Request for a Section 75W Modification to MP10_0213 - Wollongong Hospital Redevelopment.

Major Project MP10_2013 for the redevelopment of Wollongong Hospital was approved by the Department of Planning and Infrastructure on the 8 June 2012. Since that time the approval has been modified on two (2) occasions under section 75W to include the additional car parking and to amend the building façade of the Elective Services Building.

The purpose of this modification is to amend the materials and finishes or the car park, to reduce the queuing length required and to amend the landscaping in response to these modifications. The modifications are illustrated on the attached plans and are described as follows:

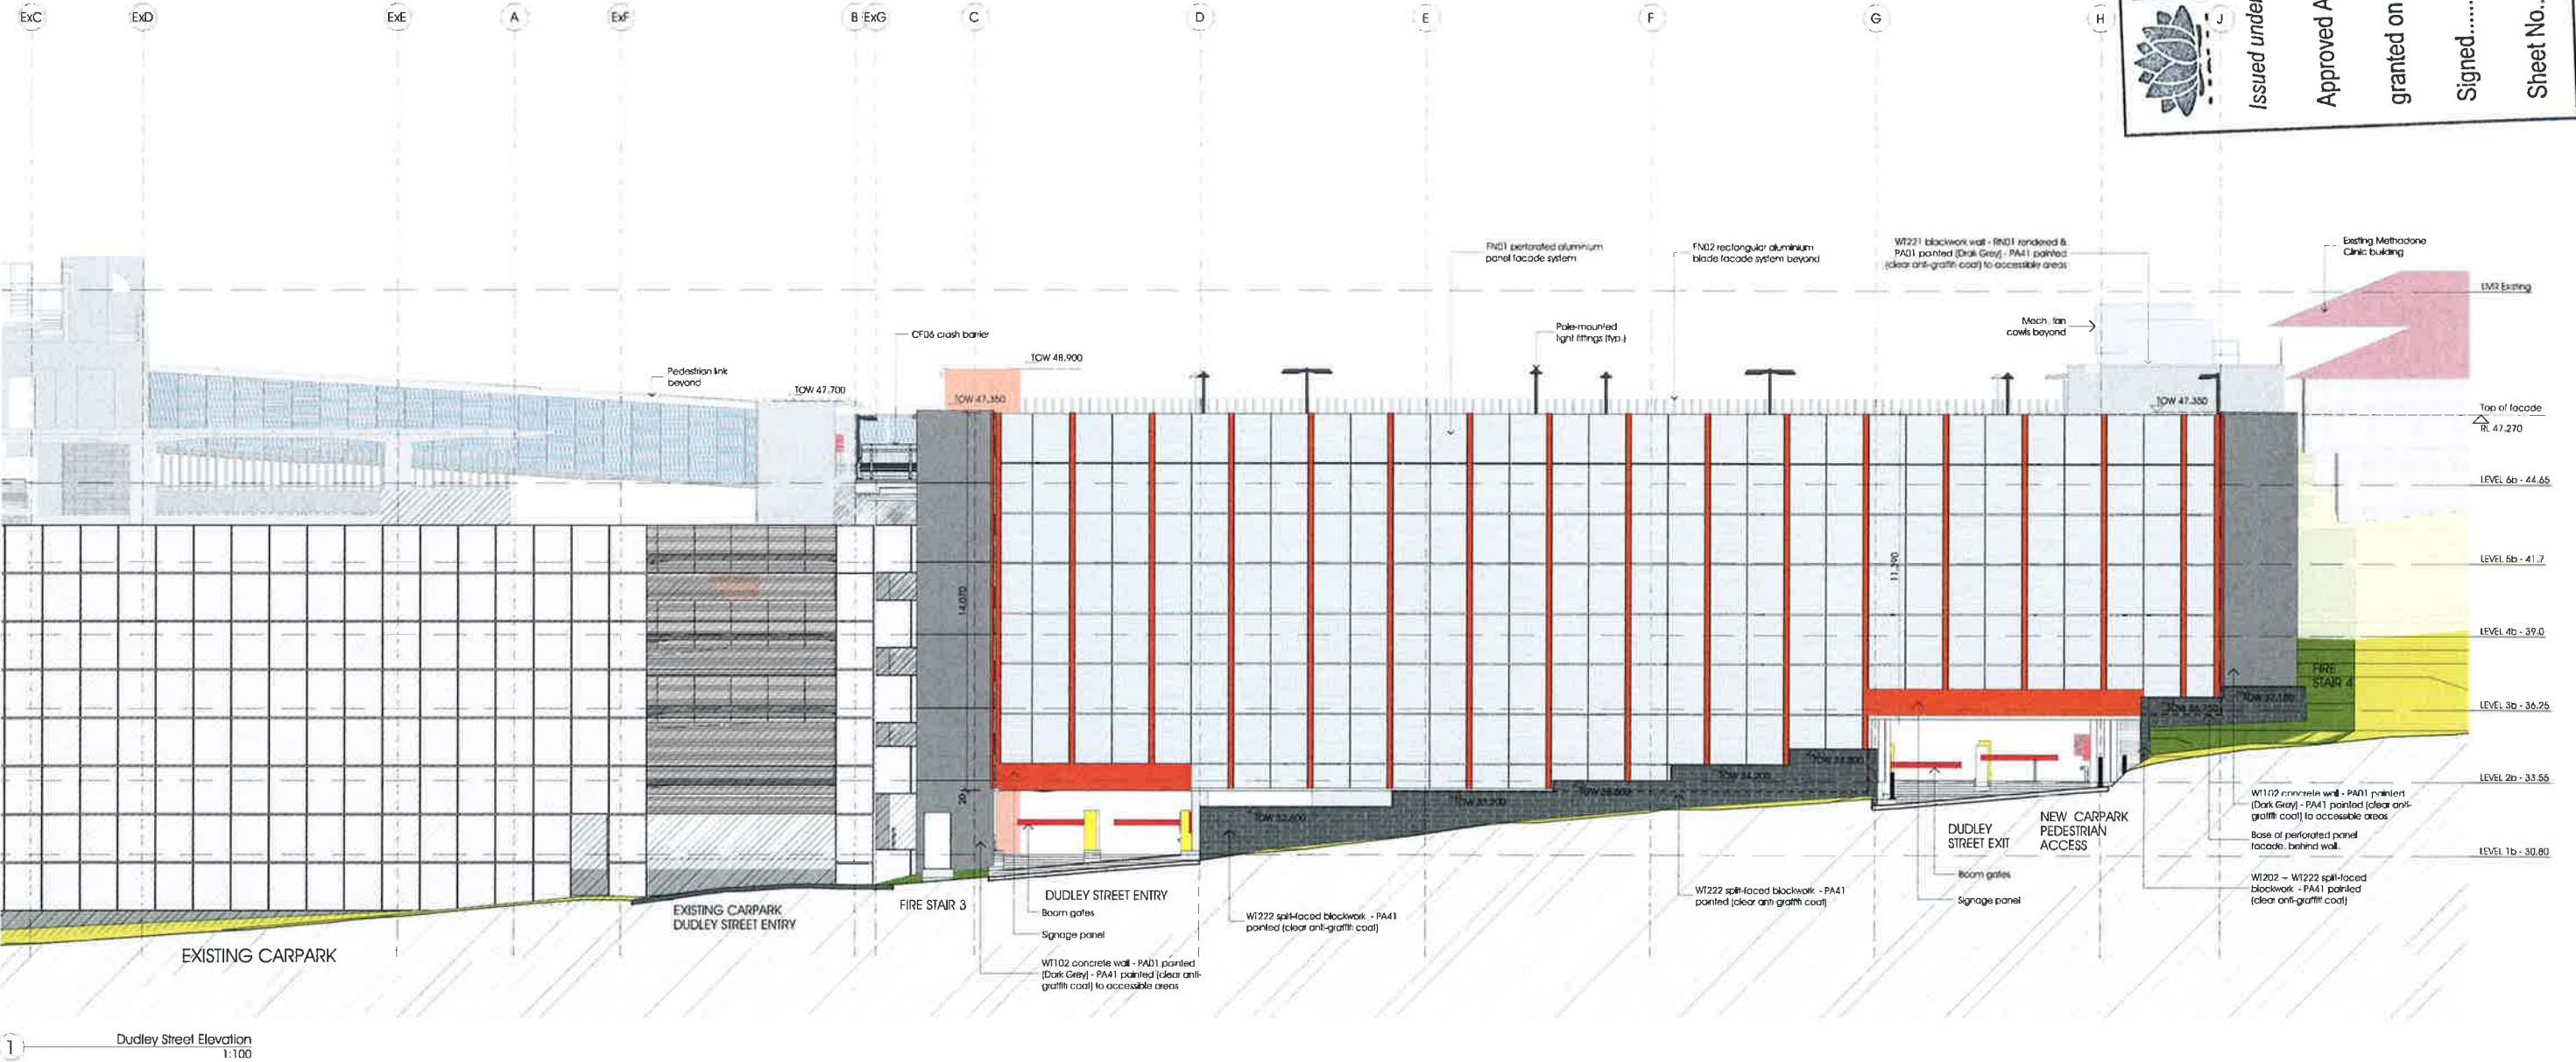
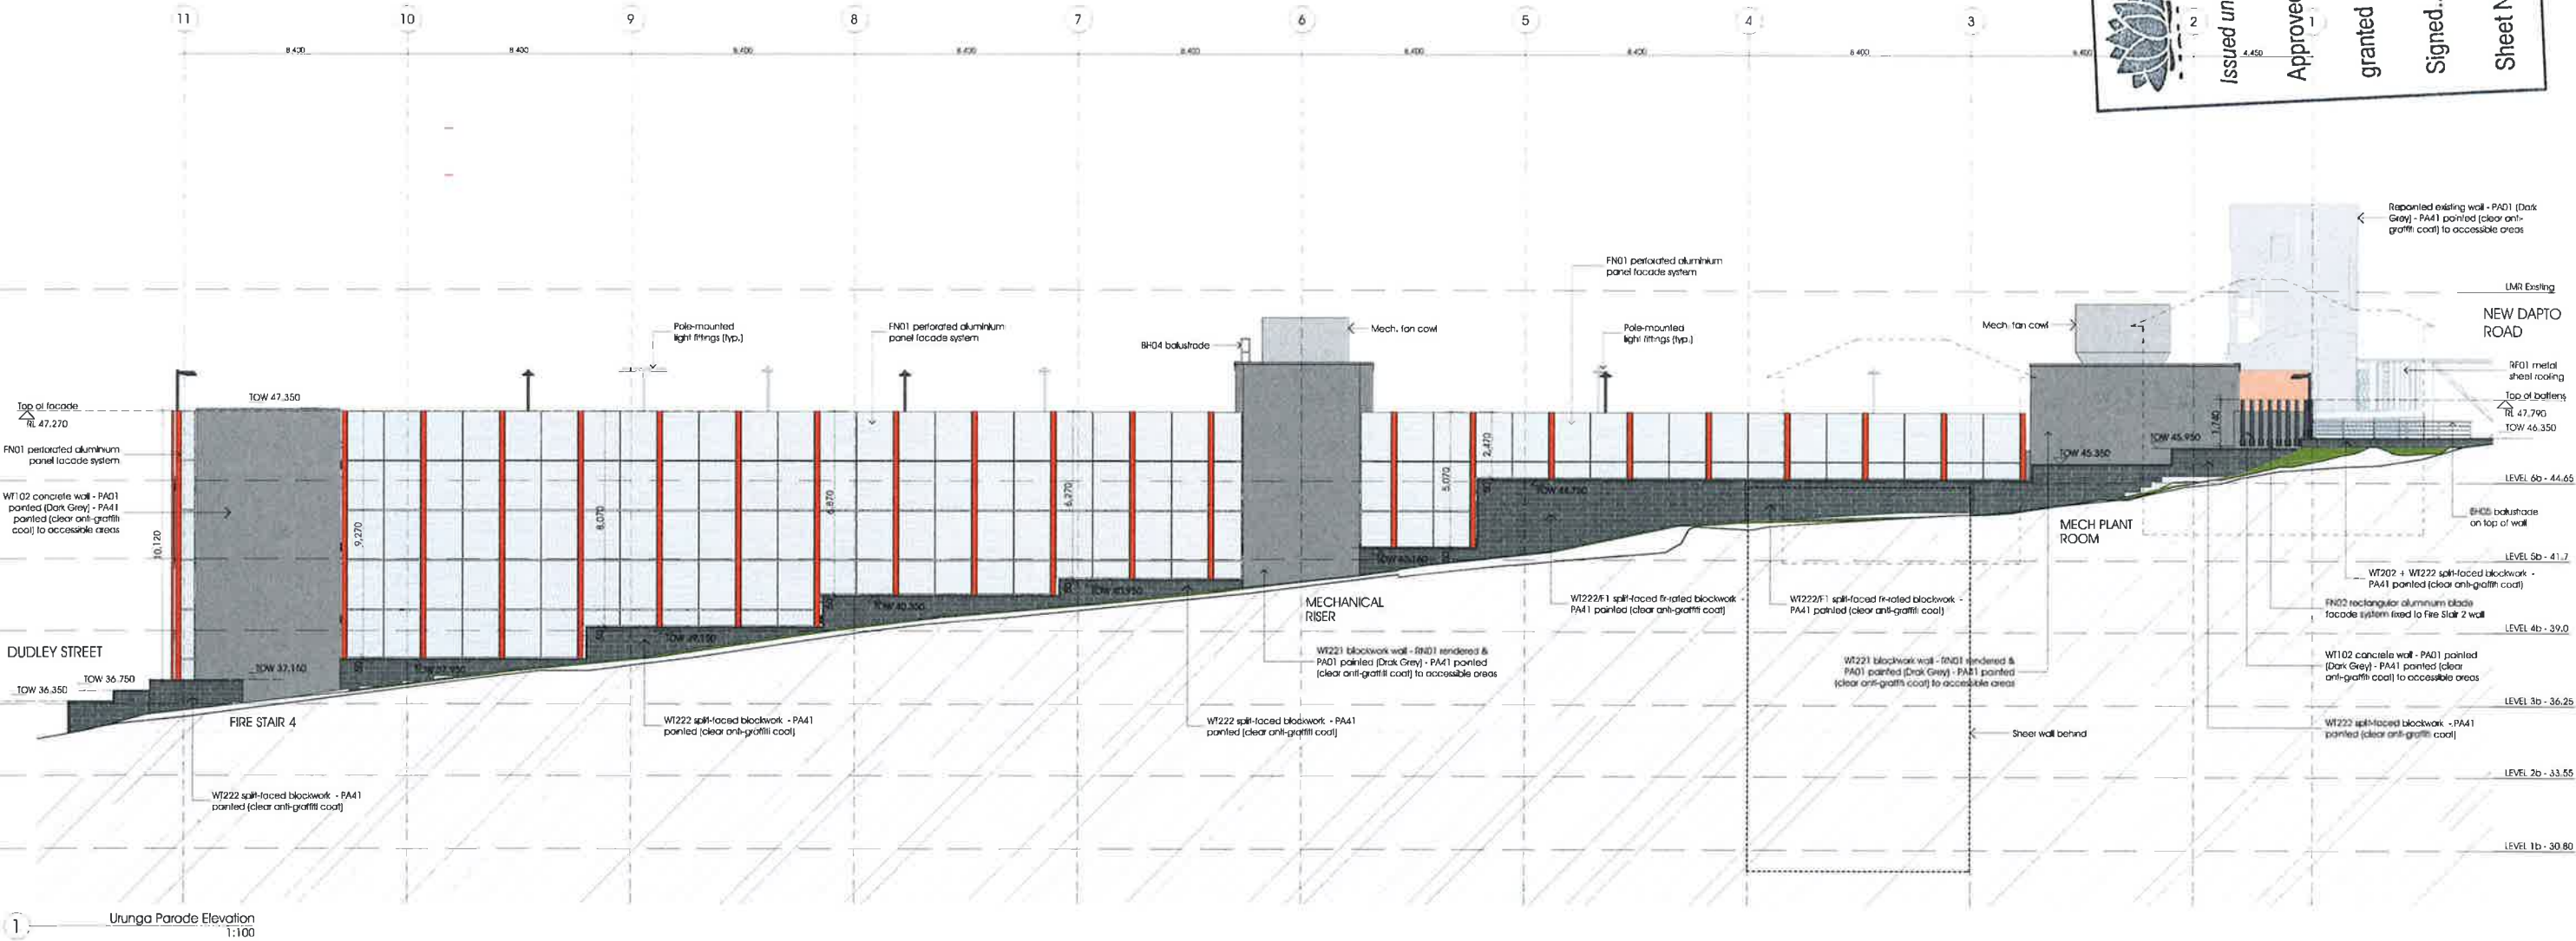
It is proposed to amend the material used for the battens fronting New Dapto Road from recycled hardwood timber to rectangular aluminium posts with a powder coat finish, as illustrated by 21225 A0-200 Issue 01 (enclosed). The battens would remain at the same height, (RL 47.790), with similar dimensions and spacing. The visual permeability and scale of the façade treatment would not change, nor would the delineation of space between the public and private realm.

The extent of the aluminium batten façade would be amended on the New Dapto Road frontage with the battens wrapped around the proposed stair well, breaking up the mass of this building, rather than spanning the space between the existing and current buildings.

The use of aluminium battens would provide a more robust material requiring less maintenance and lower installation costs. The revised material would complement the aluminium mesh finish, ensuring that a visually interesting façade design remains, while reducing capital and ongoing maintenance costs.

The retaining wall finishes would be amended from gabion and stone face finishes to split-faced block work. The revised material would retain the highly textured finish of the retaining walls to add interest and ensure that the walls present as a solid mass providing a visual grounding for the development.

The incorporation of a fire rated blockwall on the southern elevation adjacent to the existing buildings accommodating associated medical uses would ensure compliance with Building Code of Australia requirements. Additionally, the finish of the mechanical vent shaft fronting onto Urunga Parade is proposed to be revised from metal cladding to painted render block work.

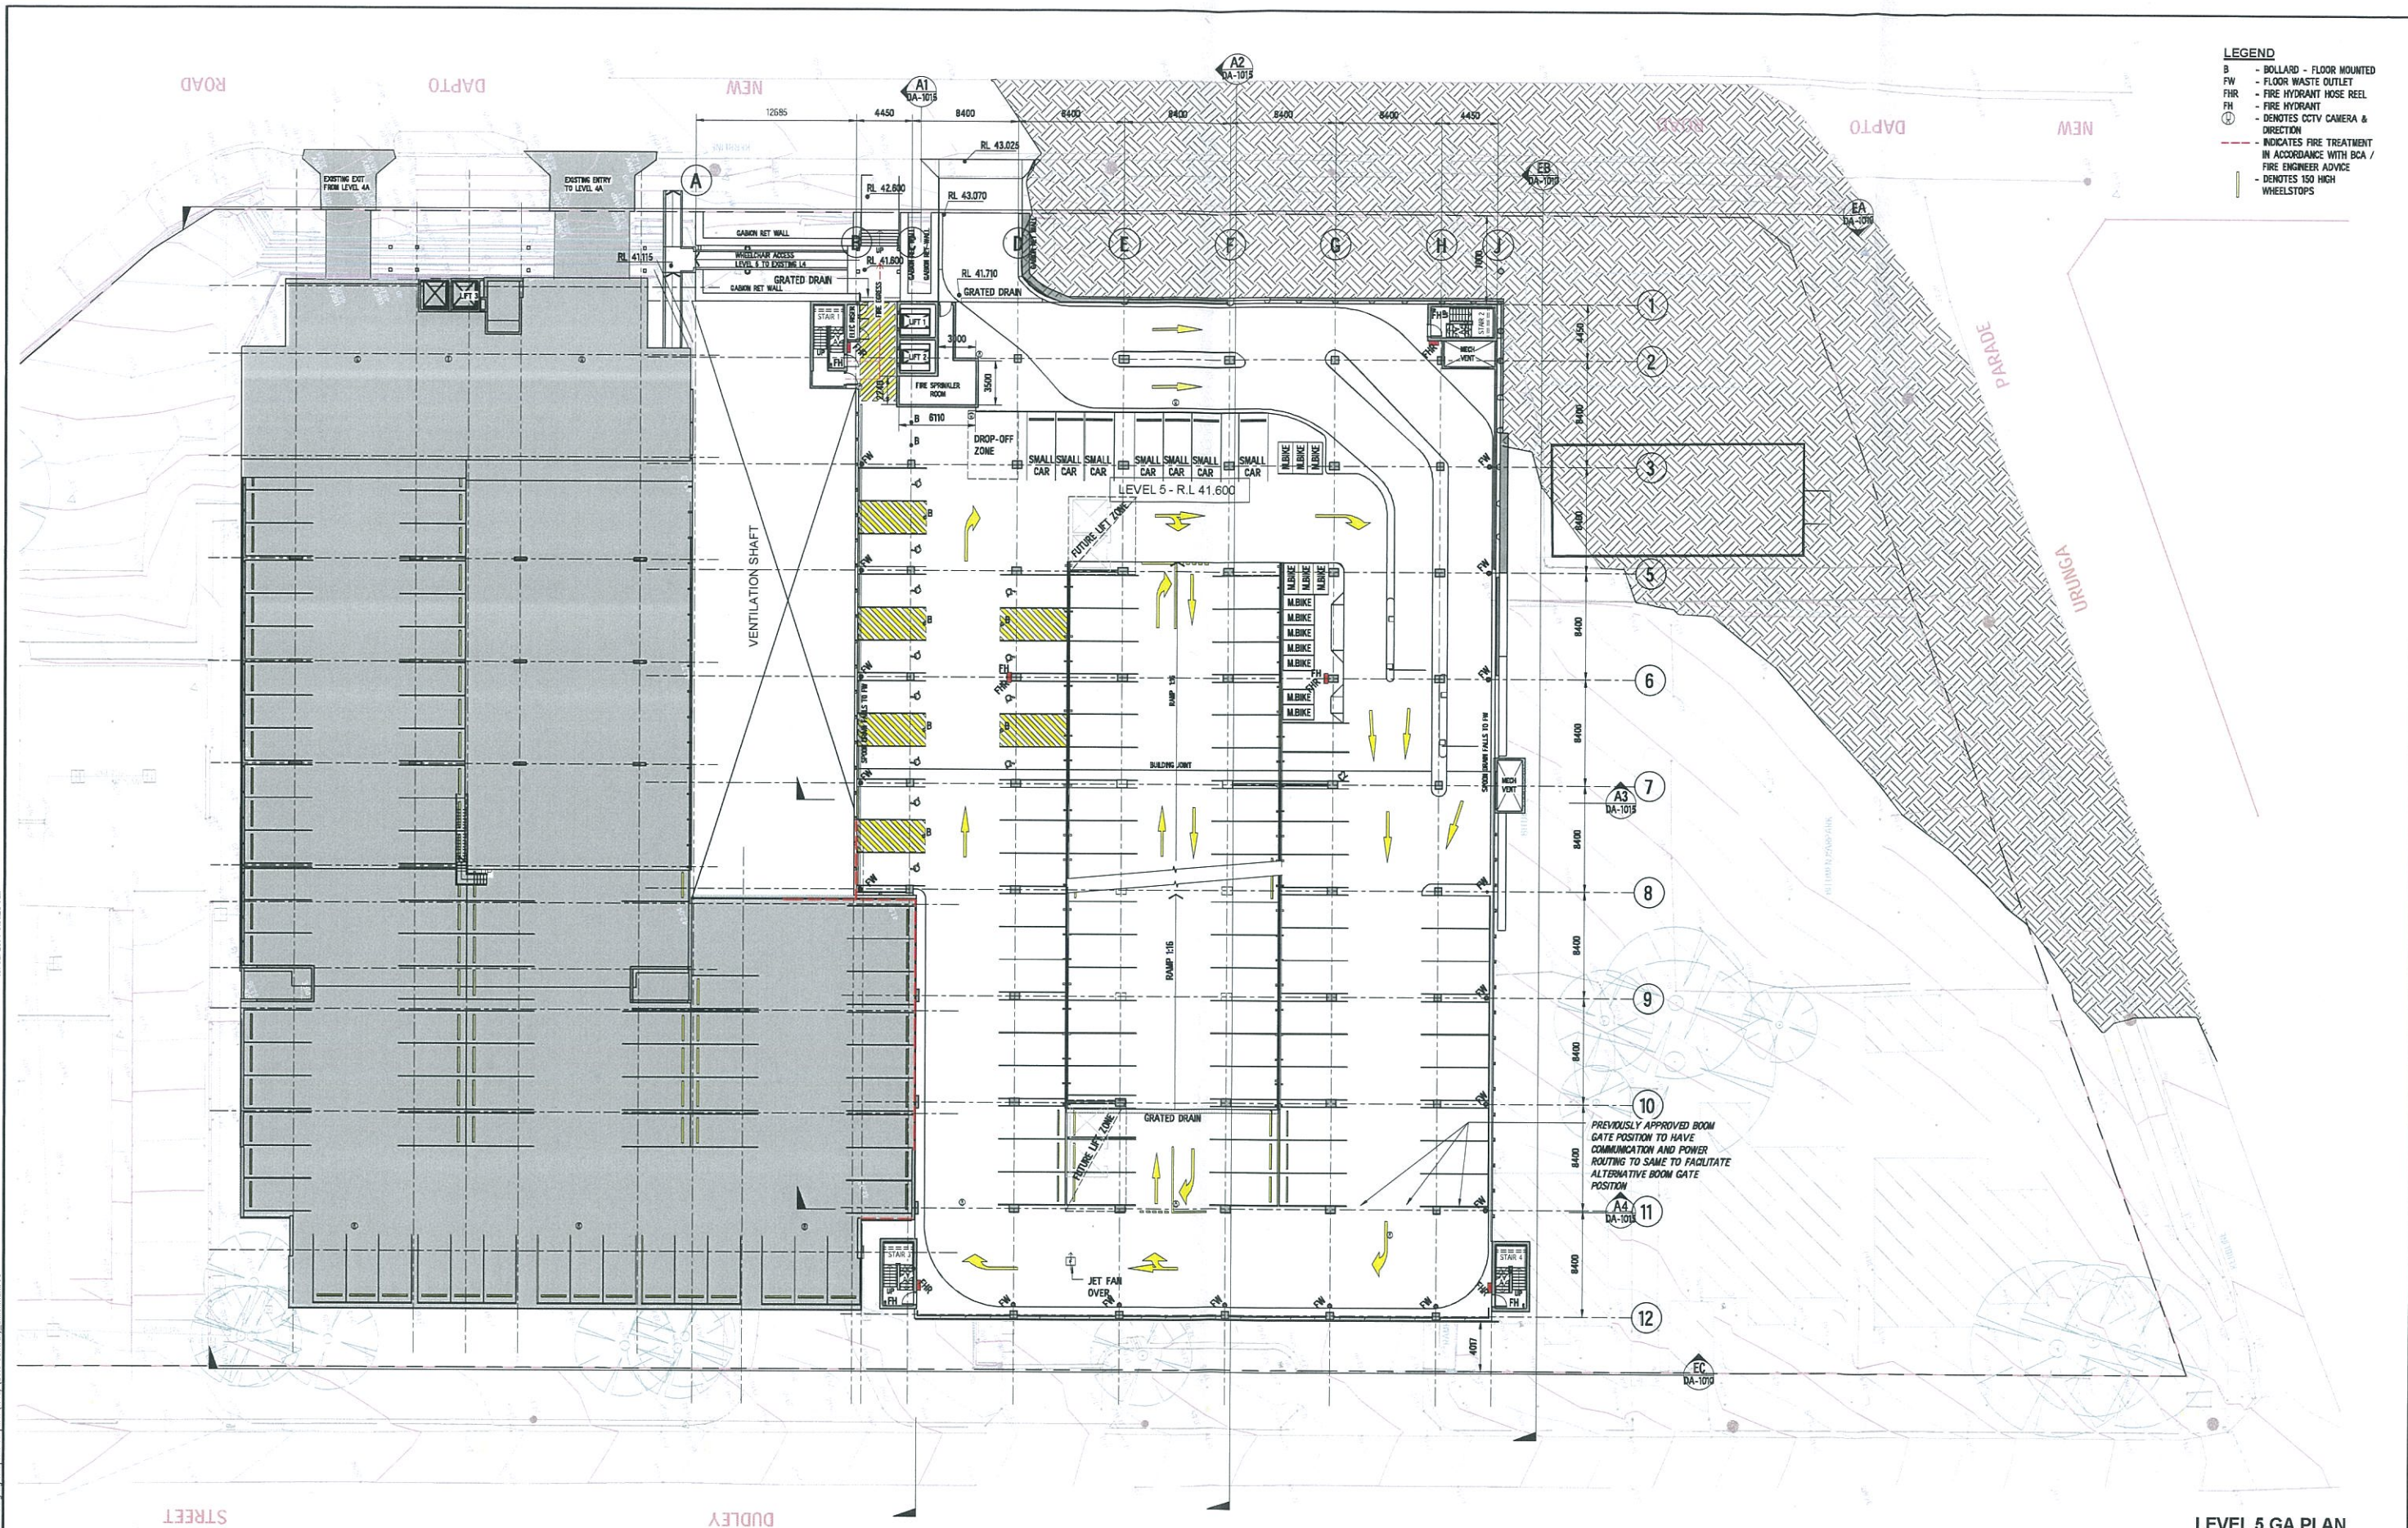
Queuing Lanes

The existing approved parking layout as identified by drawing NA80813070 DA-1005 Rev D included queuing of 33 car lengths at the New Dapto Road access prior to the boom gates in accordance with Table 3.3 of AS2890.1. An assessment of the New Dapto Road and Dudley Street car park entry points has subsequently, been undertaken by Cardno. The outcome is included in the attached document titled "Wollongong Hospital Queuing Study - Traffic and Transport Technical Note – Revision 2" (Technical Note).

The Technical Note identified that the access queuing lengths within Table 3.3 of AS2890.1 provide guidance as conservative estimates where more "specific guidance" is not available to avoid impact on the adjacent road network. The Technical Note seeks to provide the "specific guidance" referred to in AS2890.1 and considers the impact of the anticipated entry/exit vehicle flow based on the statistical analysis of 'Queuing Theory'. Based on the analysis undertaken in the Technical Note, a revised design layout for the entry lanes has been provided as illustrated by the enclosed drawing NA80813070DA-1005 Rev F. The revised layout shows the entry boom gates and associated merger of the queuing lanes in the middle of the car park, rather than towards the western side of the car park as originally proposed.

The revised layout provides for 20 car lengths of queuing, which based on the Technical Note analysis is considered acceptable subject to a number of management measures being employed to reduce the number of cars accessing the parking spaces located immediately adjacent to the boom gates. The proposed management measures to allow the free flow of traffic in proximity to the boom gate merger are discussed in the Technical Note.
